Recommendation Report for Planning Permission for Works or Extension to a Dwelling

REF NO: EP/165/21/HH

LOCATION: 12 Tamarisk Way
East Preston
BN16 2TF

PROPOSAL: Single storey rear extension.

Drawing No Status Revision
213080/ 03

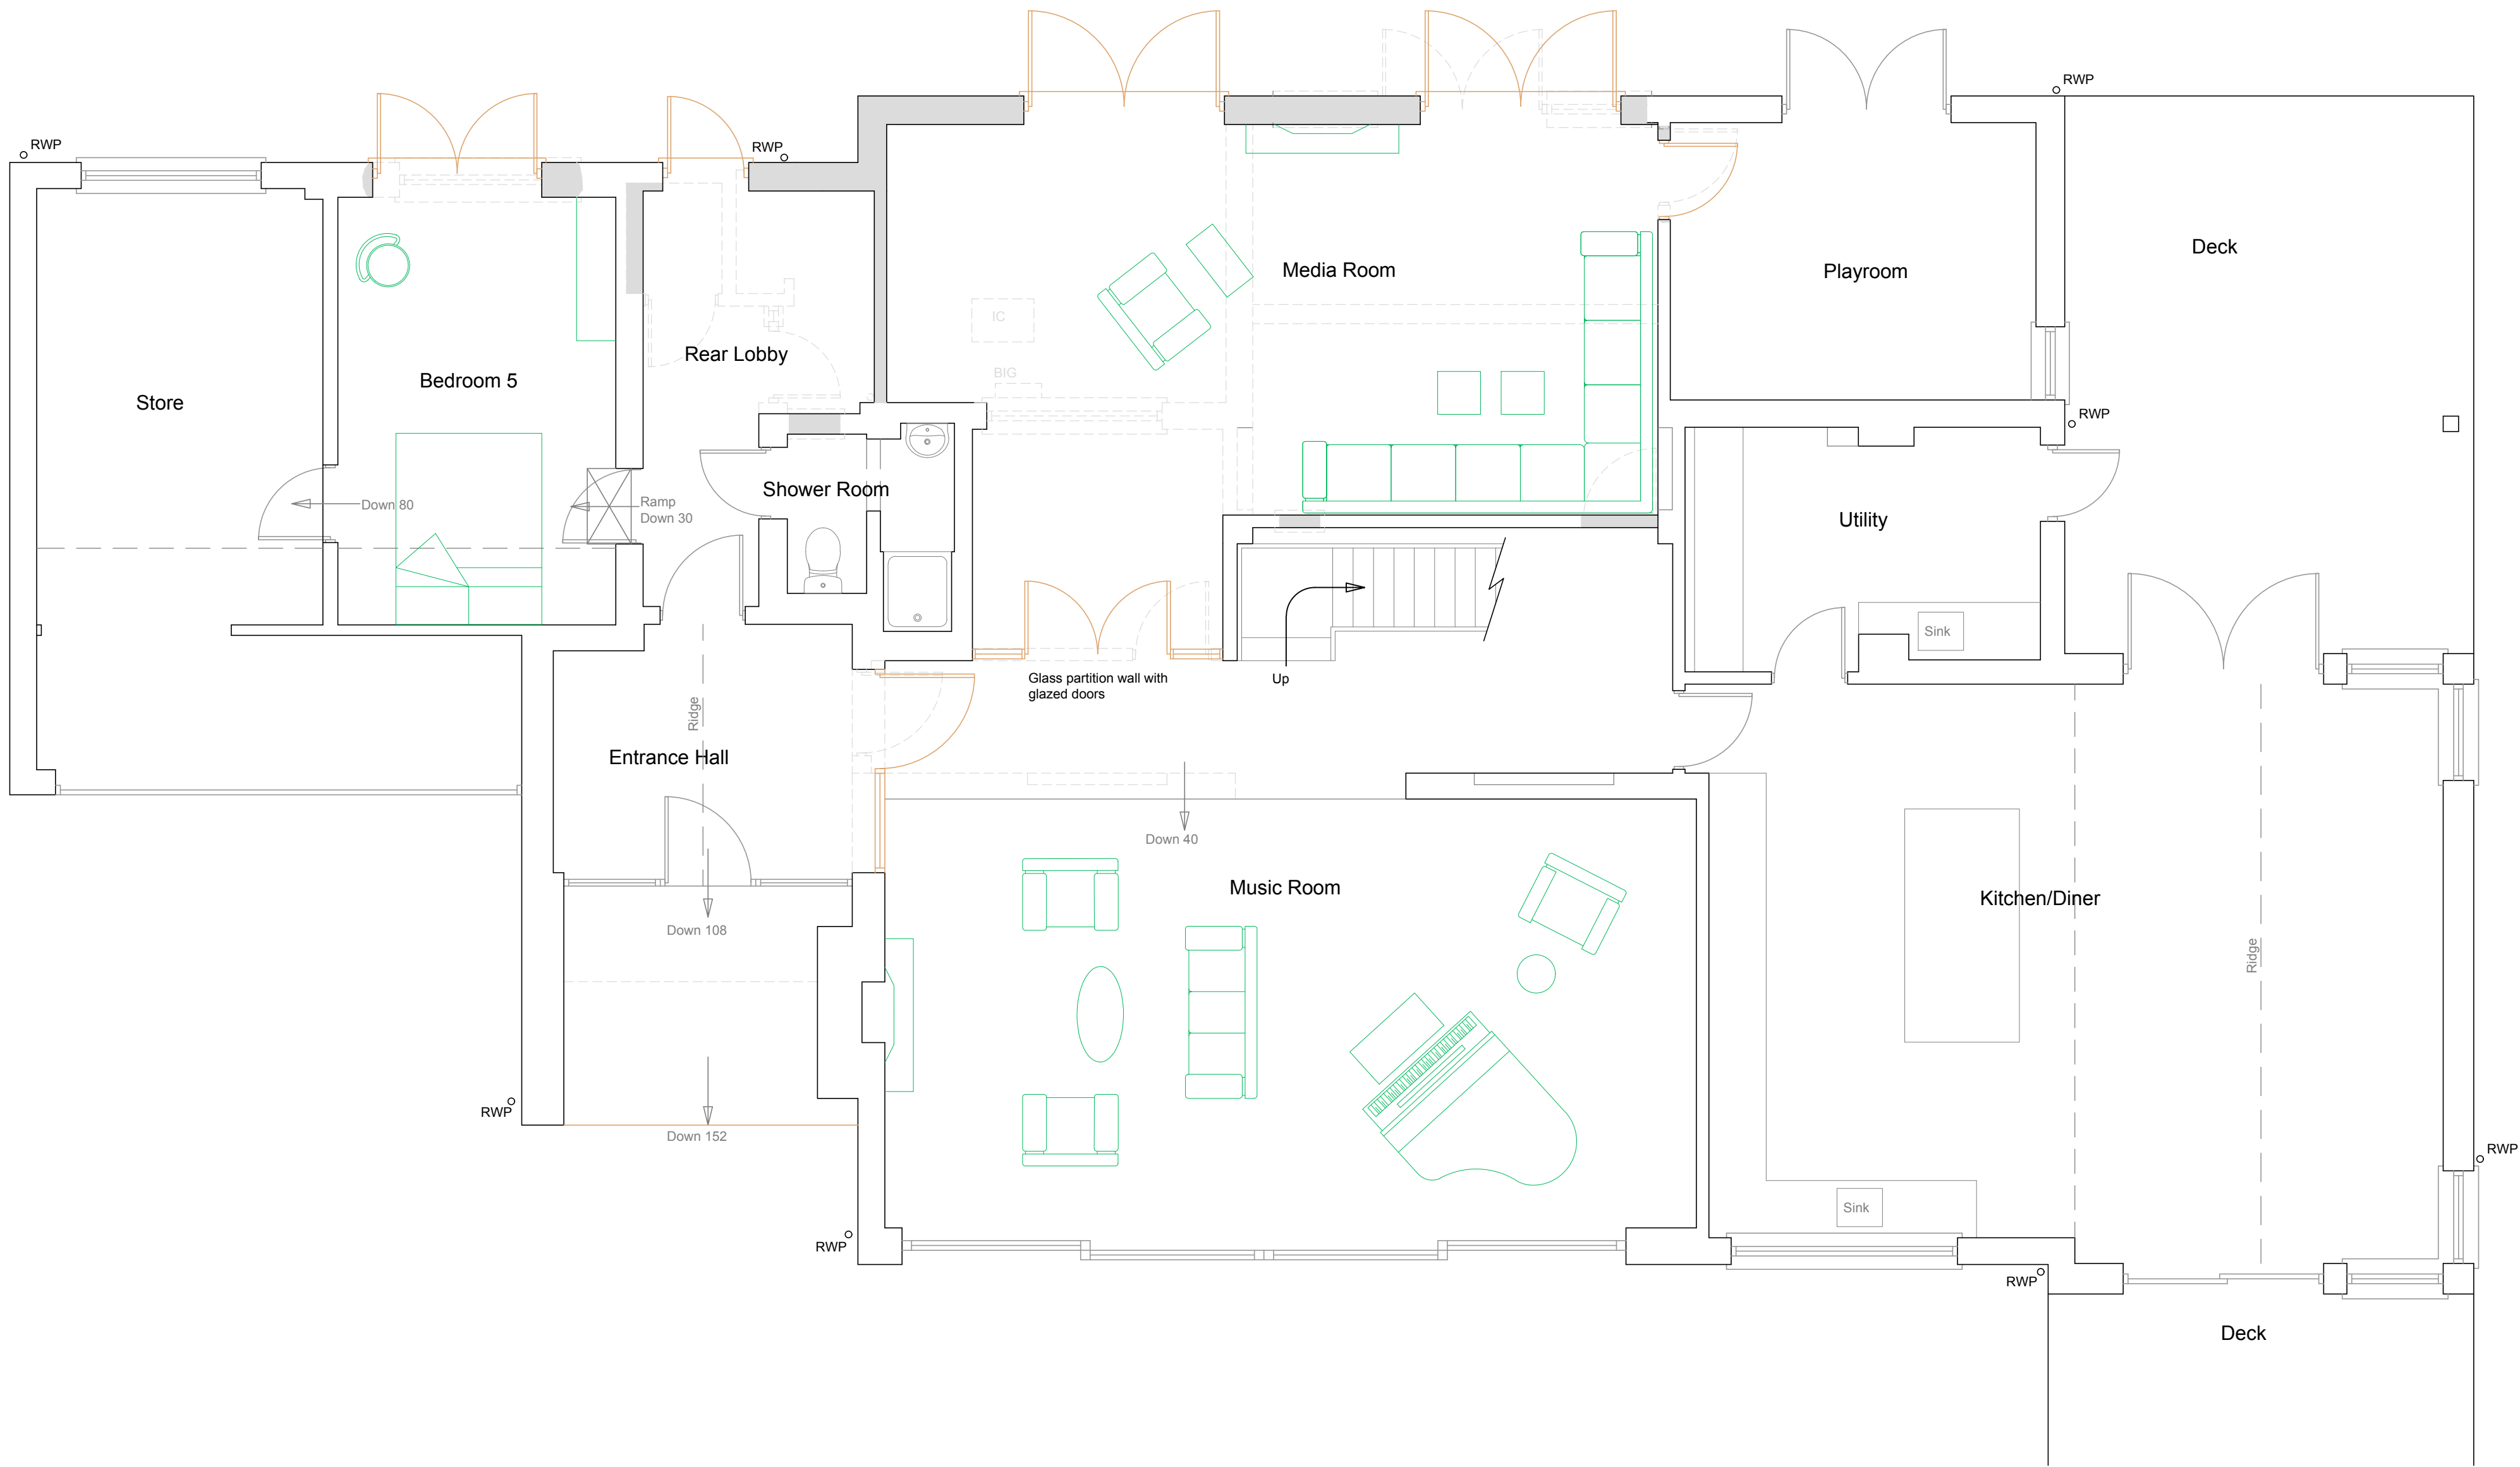
The proposal is a single storey infill extension, connecting the rear lobby to the media room, both of which will be extended. The works will include the installation of 4 new doors, 3 of which being doubles, all to the rear elevation. The rear lobby will have a flat roof, matching that of the existing, and have a width of around 2.2m and depth of 2.5m. The new part of the media room will have a width of around 3.8m and depth of 3.23m. It will extend and replace part of the existing rear wall, having a total width of around 8.25m. It will have a lean to roof, which will be a continuation of the existing. The proposal is sympathetic to the design of the host dwelling and will have minimal impact on its visual appearance and character. Being to the rear, the extension retains no distance to the front boundary and poses no risk of disrupting the composition or rhythm of the street scene.

213080/ 05

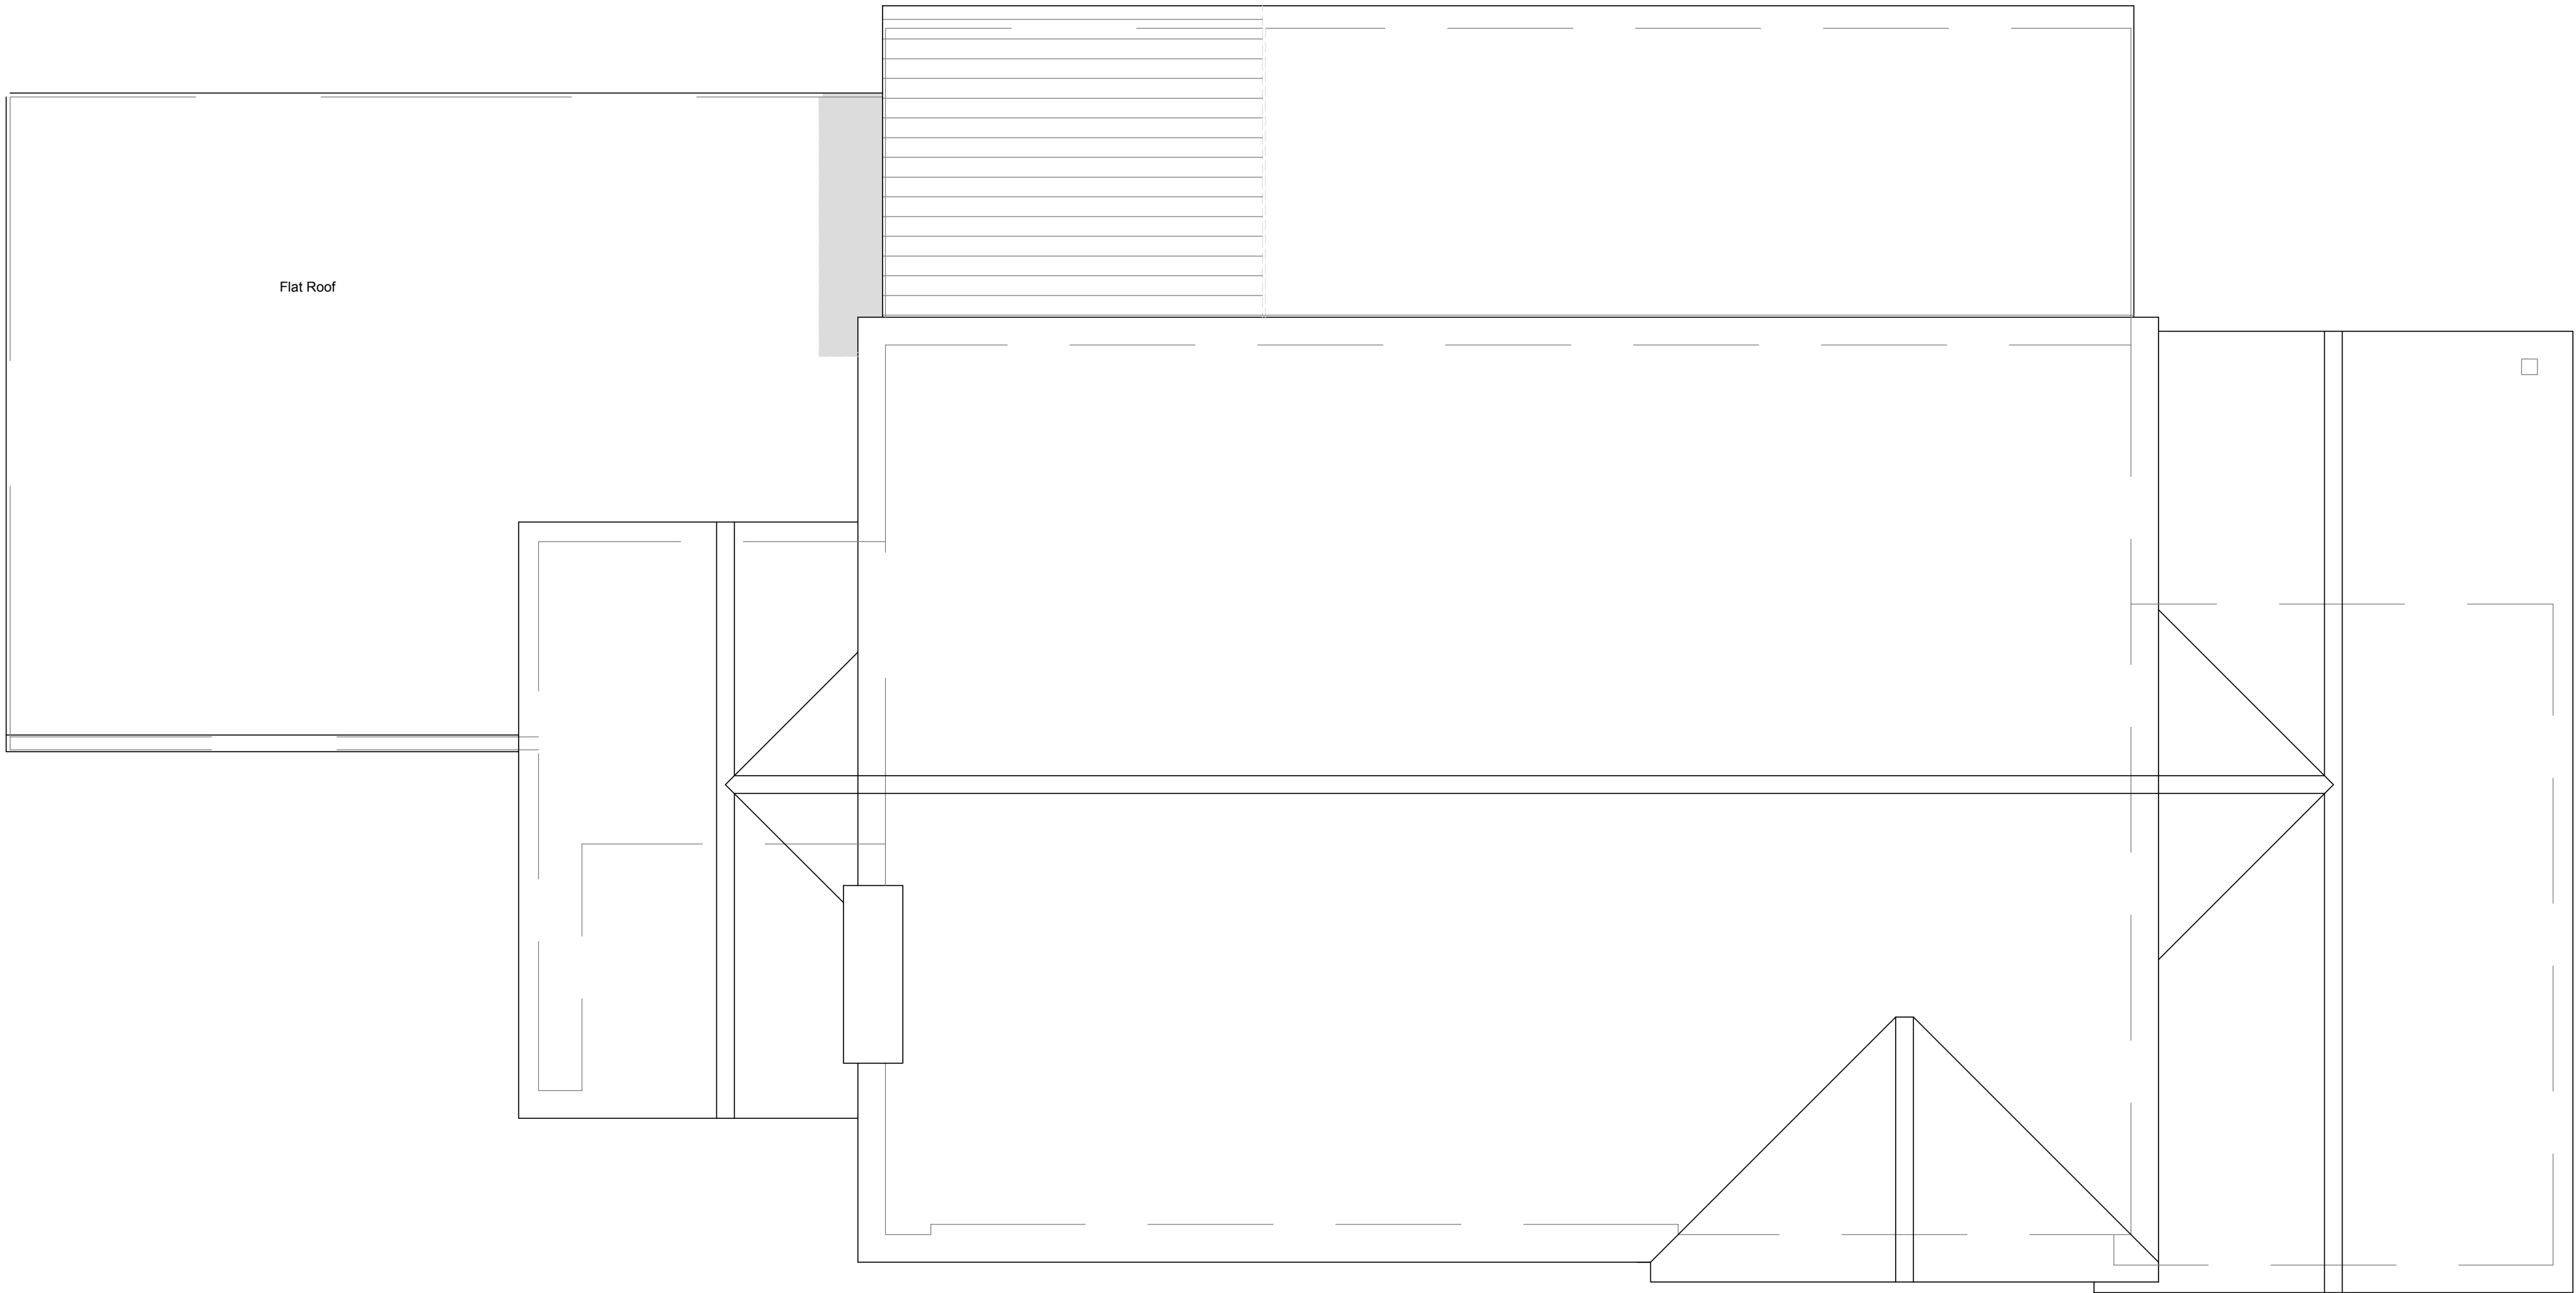
The extension will be to the rear and will be single storey. It will have a flat roof with a height of 2.65m and a lean to roof with a height of 3.8m, measuring around 2.57m at the eaves. Being an infill extension, it has no direct distance to any side boundaries, only retaining a distance of 28.9m to the rear boundary. The proposal is not considered to be harmful to residential amenity and does not give rise to any overshadowing or overbearing. This is in accord with D DM4 of the Arun Local Plan.

1:100 at A1		
Drawing No Status Revision		
213080/ 06

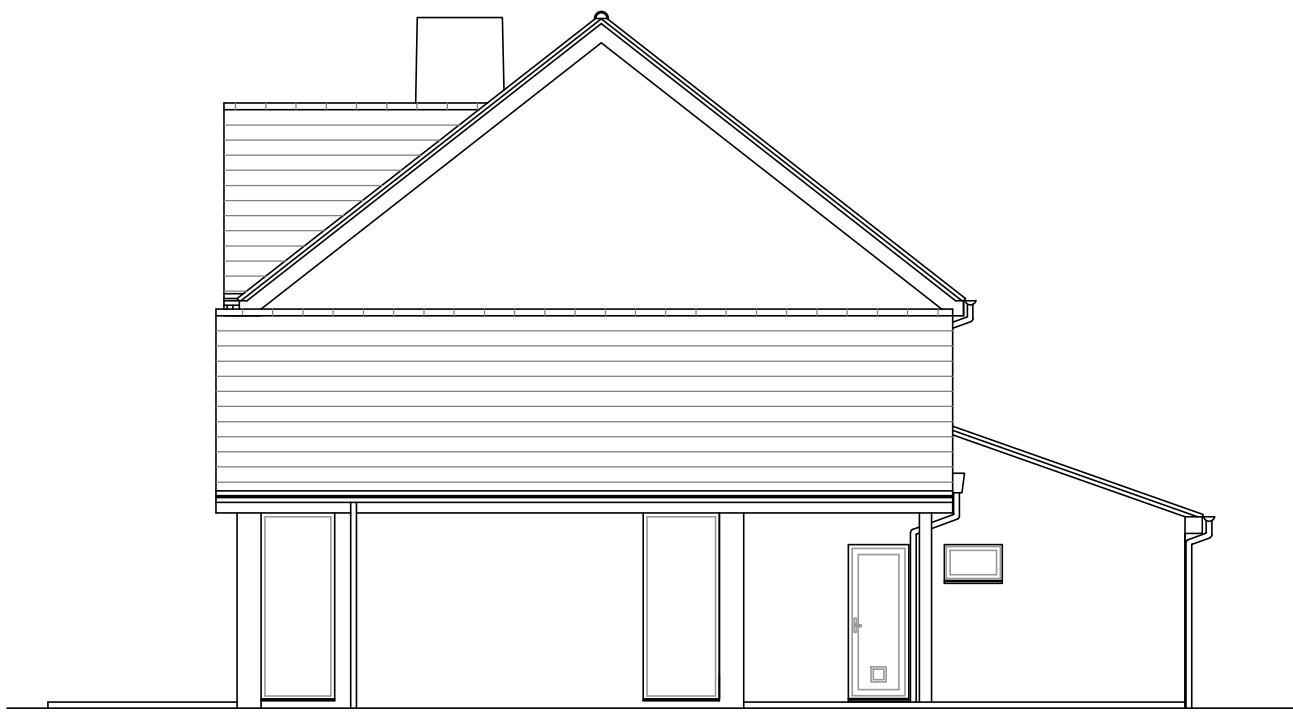
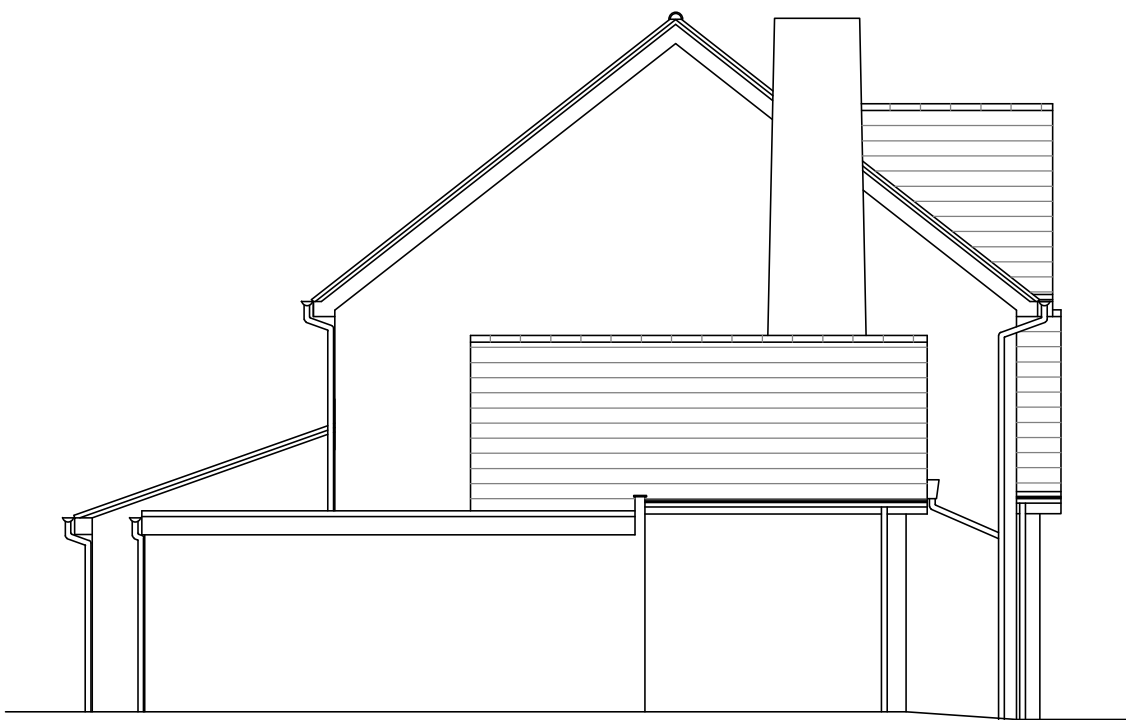
The extension features the installation of four new doors to the rear elevation. Being single storey and retaining a significant distance from the nearest property to the rear, these features give rise to little overlooking, overshadowing or overbearing and are not considered to pose adverse harm to neighbouring amenity.
